CONSTRUCTION DOCUMENTS

FALCON MARKETPLACE

ISSUE	DATE
90% SUBMITTAL	5-6-19
REVISED	8-28-20
DESIGNED BY:	TDM
DRAWN BY:	KGV
CHECKED BY:	TDM
FILE NAME:	20988-CD-CVR

COVER SHEET

C1.10

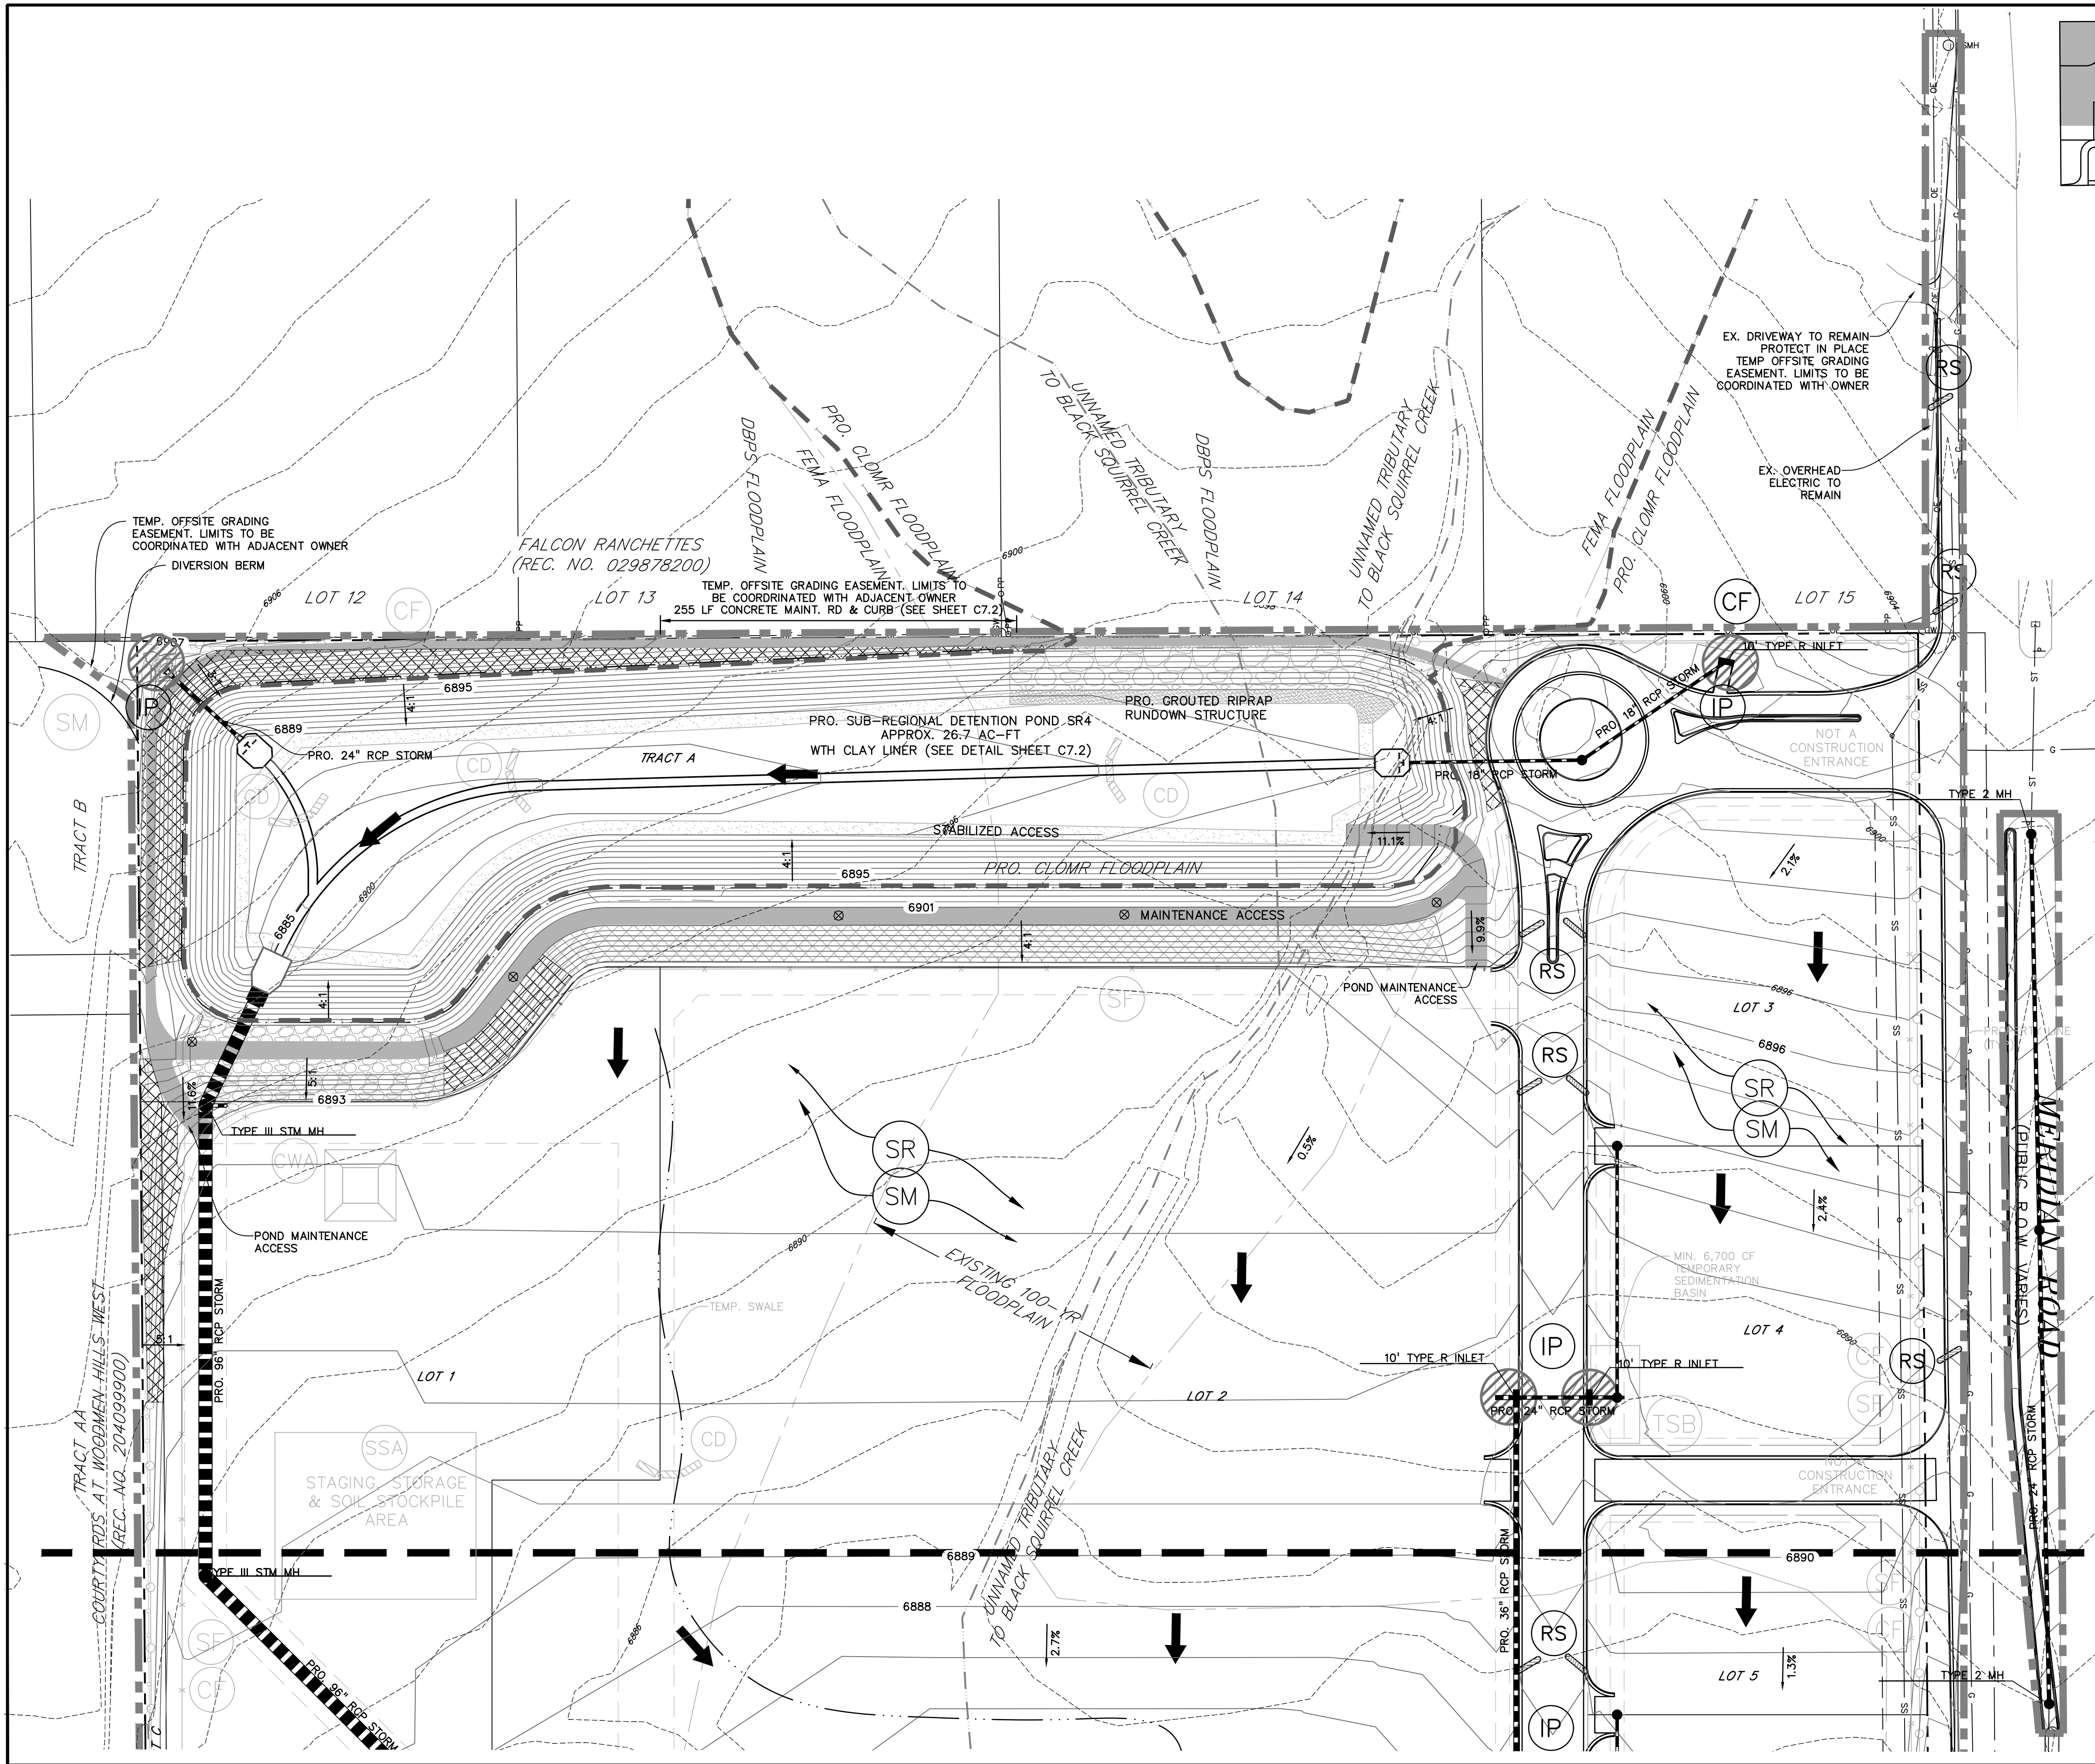
List all sheets in this set.

Provide the revised EGP sheets in this set also.
